COMMUNITY SERVICES DEPARTMENT

May 17, 2022

Subject: 9620 Chipeta Park Road Rezone (P228)

IMPROVEMENT LOCATION CERTIFICATE

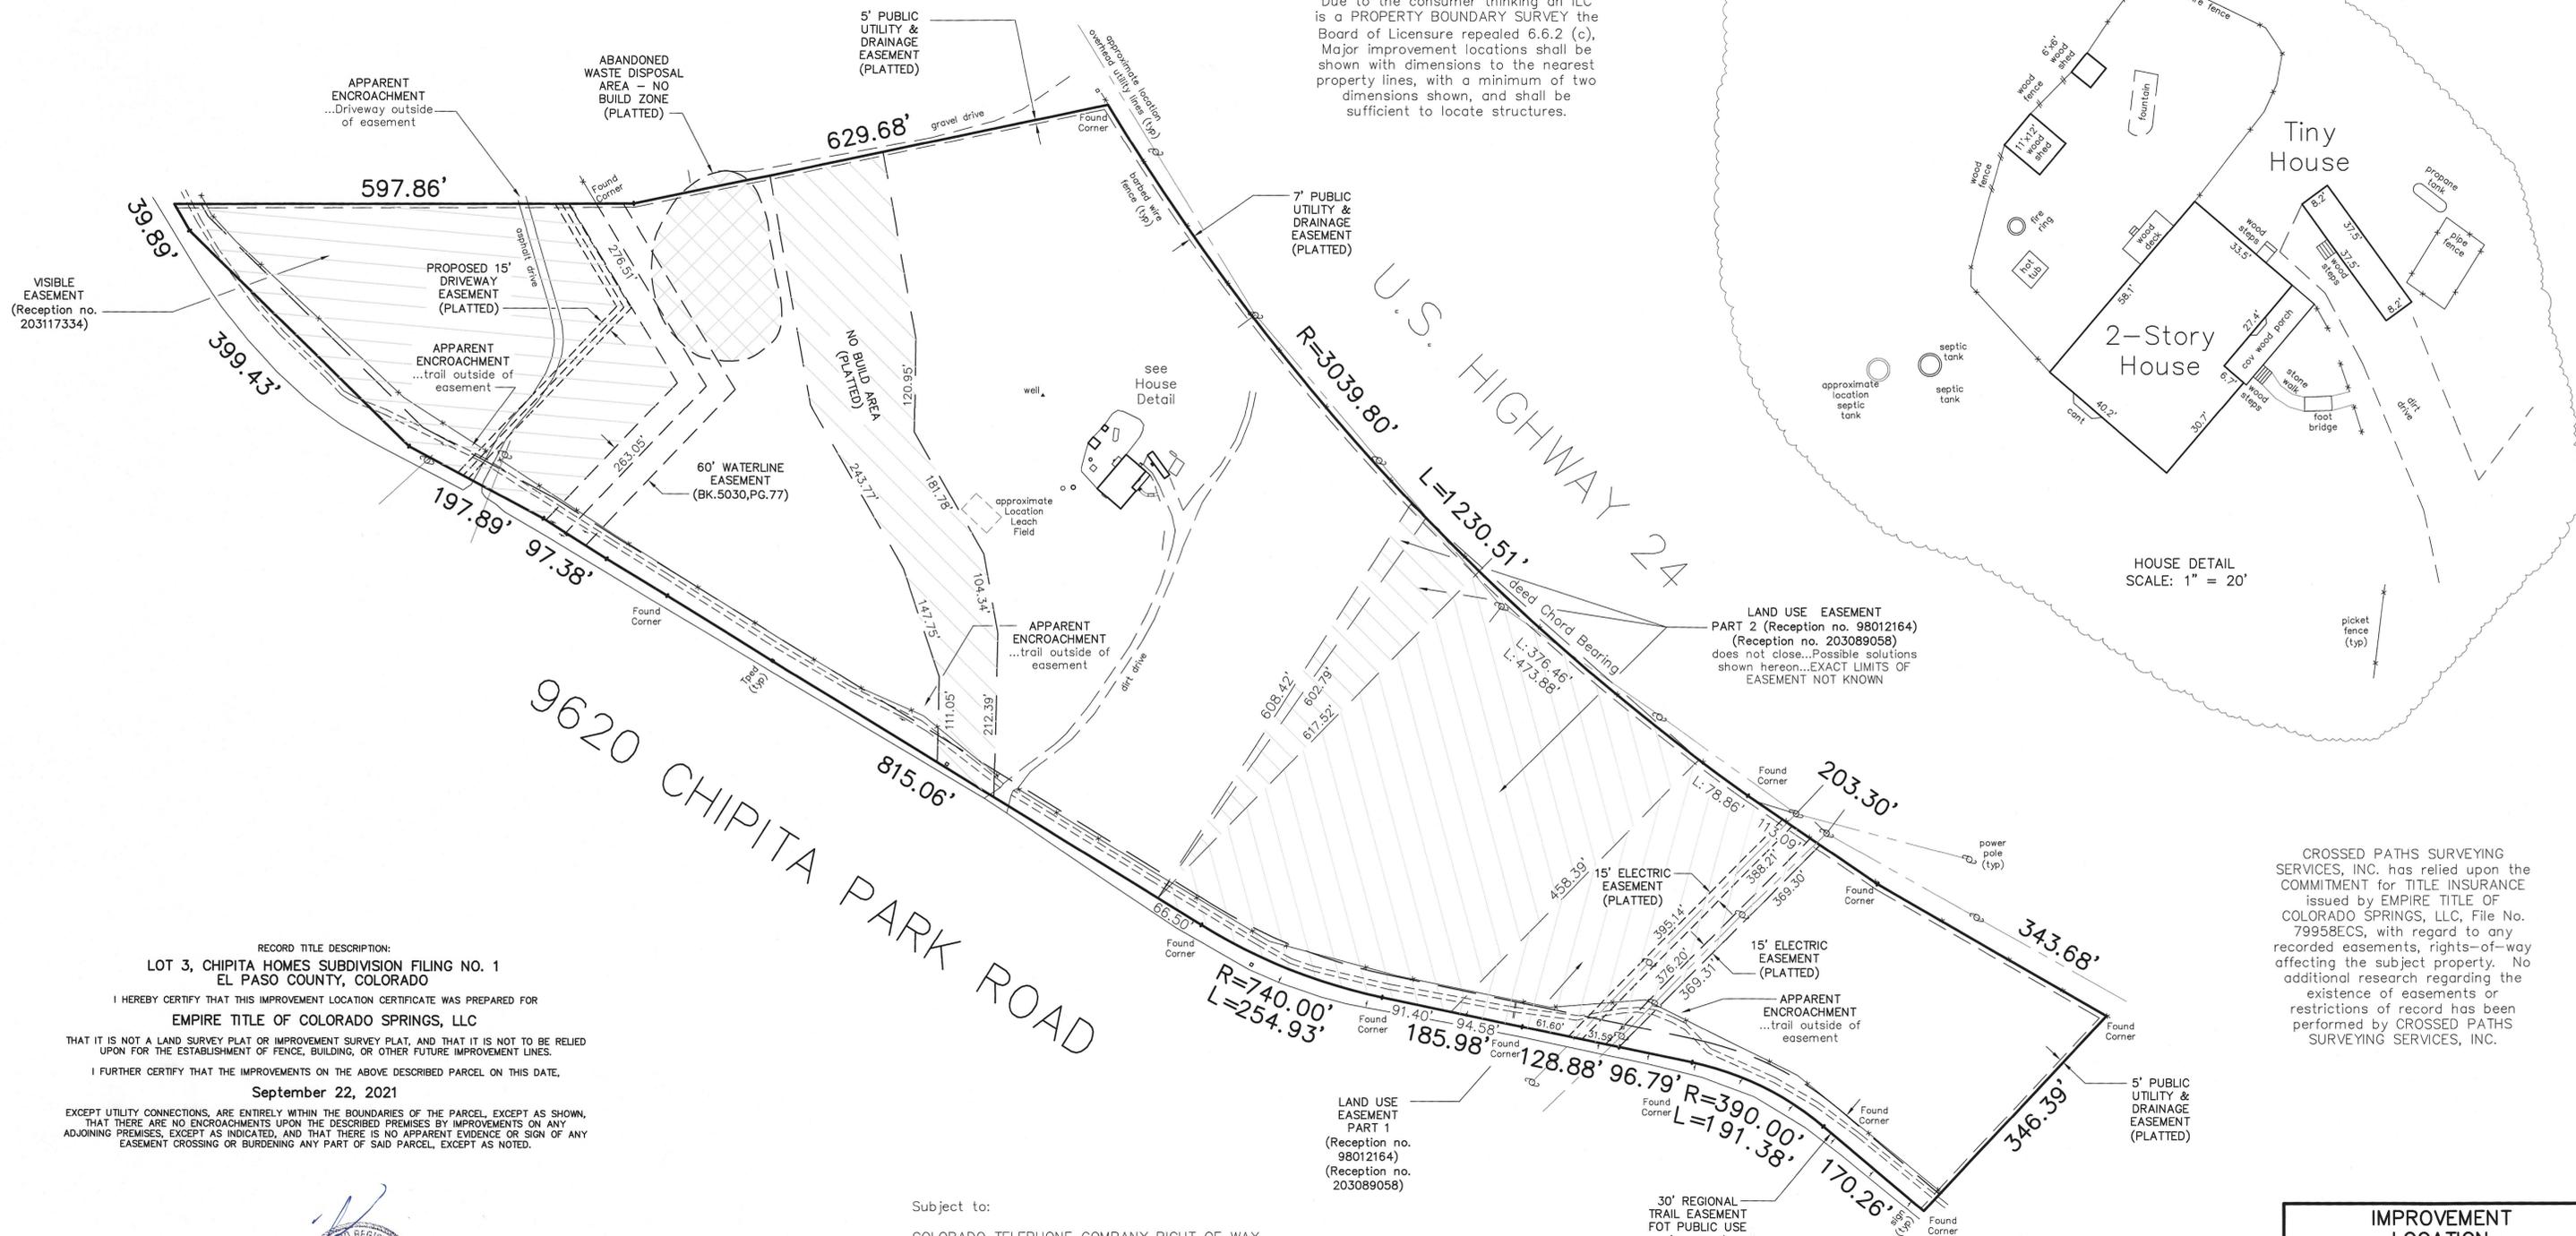
Parks staff notes the exhibits identify a tiny house on the property, however when reviewing the aerial image, it appears the tiny house is instead a recreational vehicle. The El Paso County Land Development Code (LDC) defines a tiny house as a dwelling unit with the exterior appearance of a single-family dwelling unit. Furthermore, the LDC defines a recreational vehicle as a travel trailer, camper, motor home, truck camper or similar. To ensure compliance with LDC terminology and to accurately identify current land uses, Parks staff requests the applicant correctly identify the site improvements and use the appropriate terminology outlined in the LDC.

REZONING MAP BONSAI VILLAGE

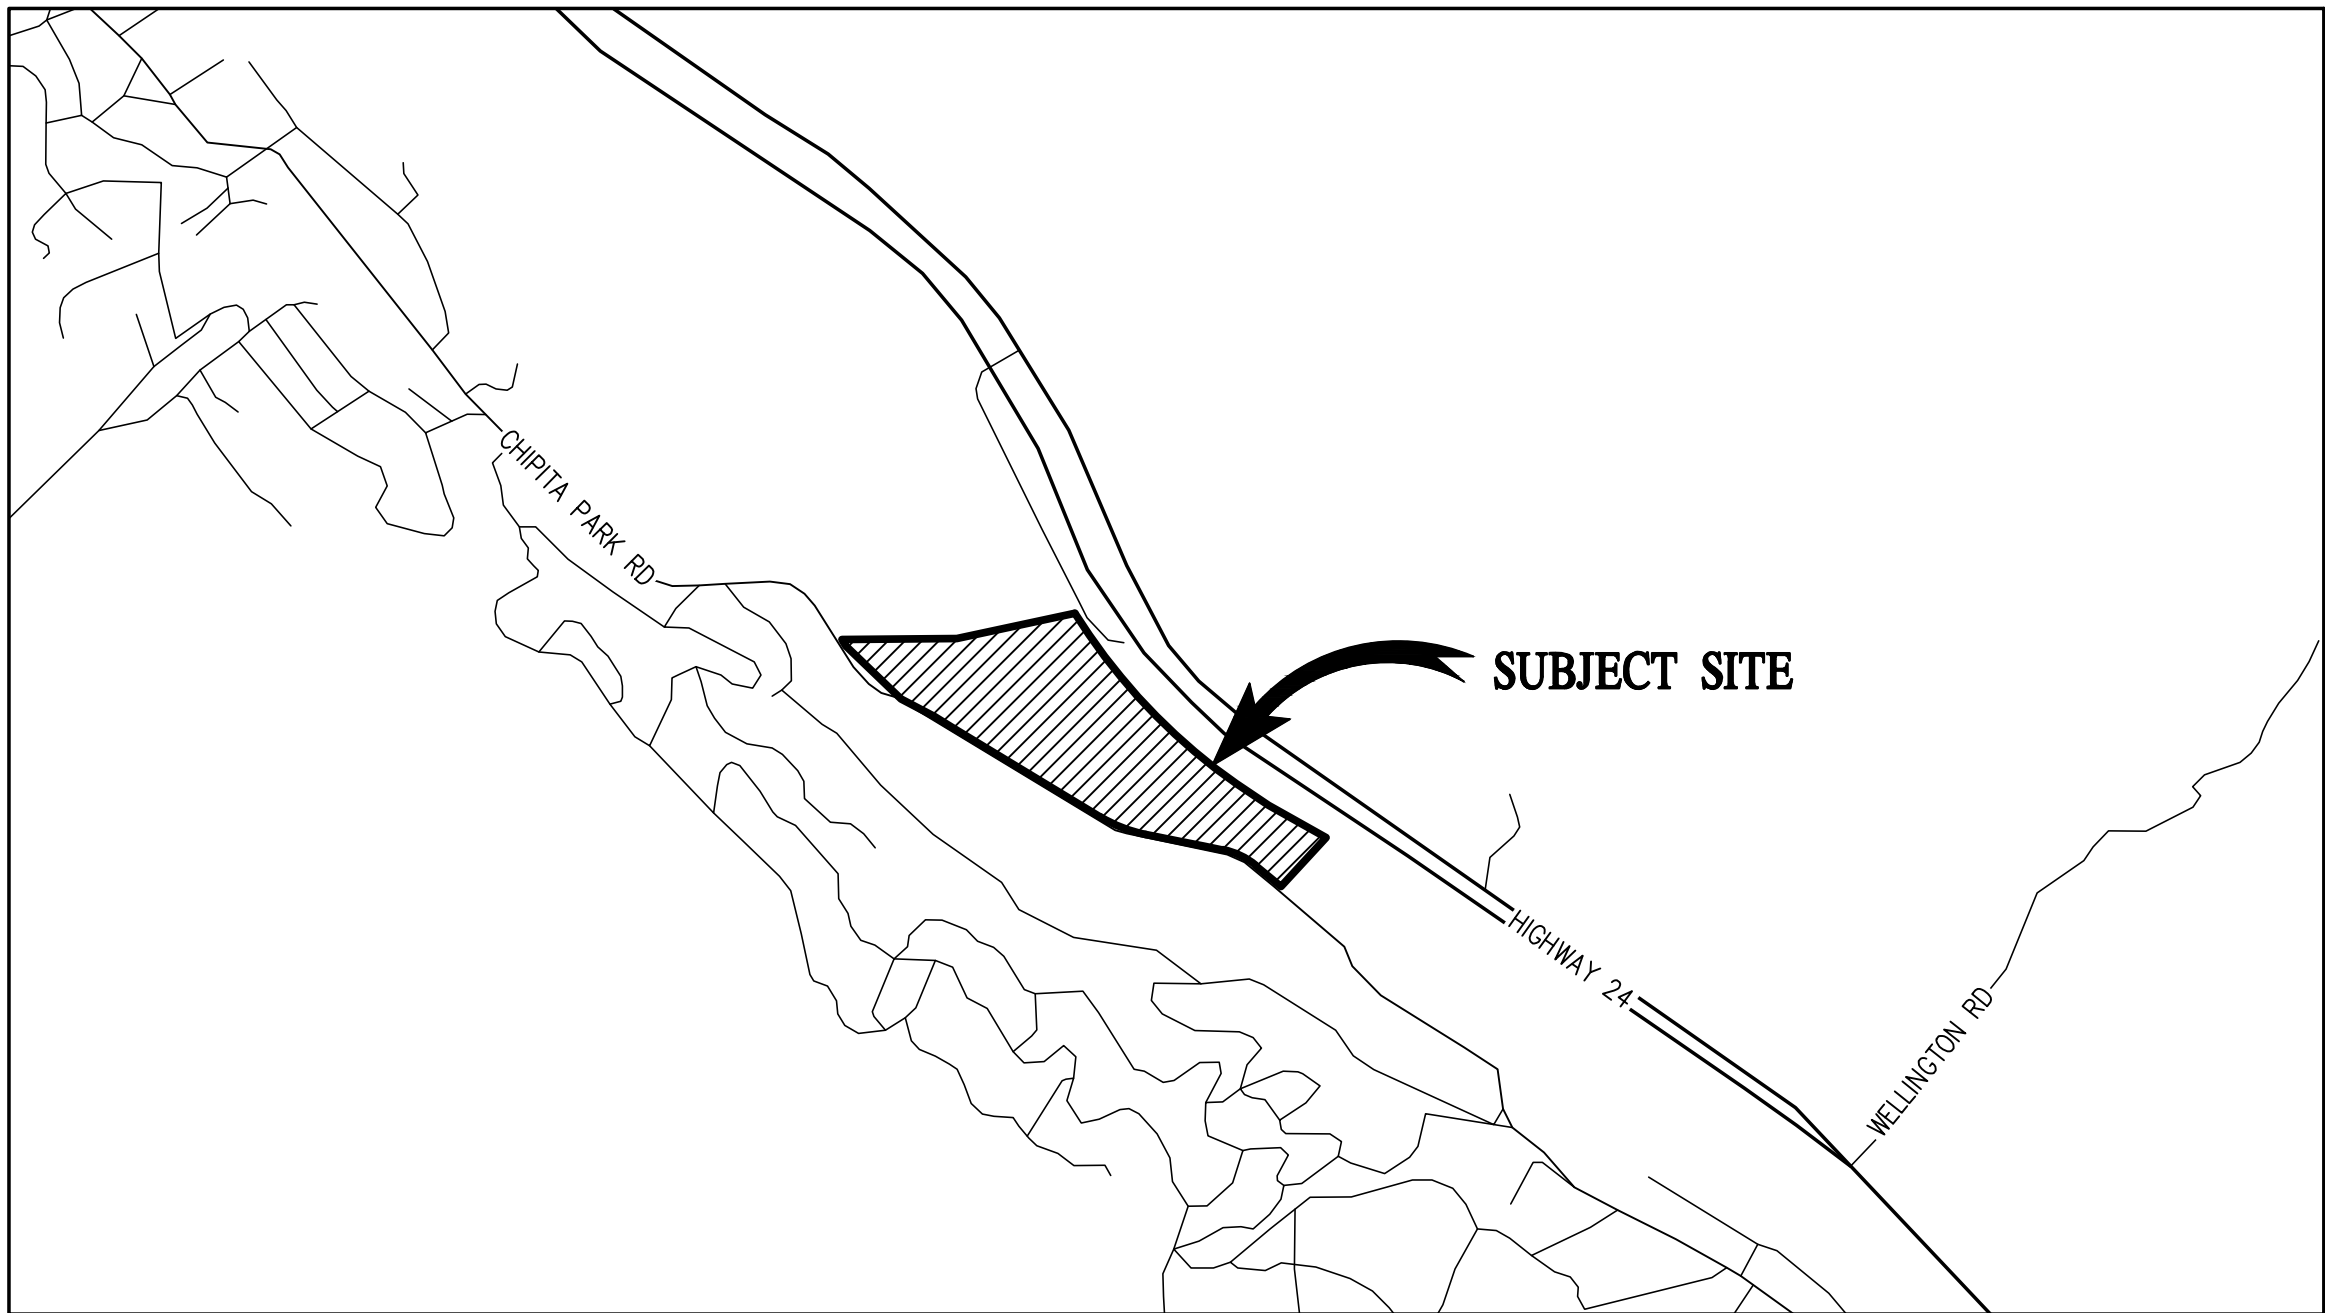
Parks staff notes the exhibits identify several areas where the trail is assumed to be slightly outside of the provided trail easement. This may be a result of several reasons, which may include, changes during construction to avoid

obstacles, utilities, reduce site impacts/erosion, or to provide a better crossing of driveways. Parks staff recommends amending the easements shown on the exhibits to match the current alignment of the trail to resolve this issue since the trail has been used in its current configuration since 2003.
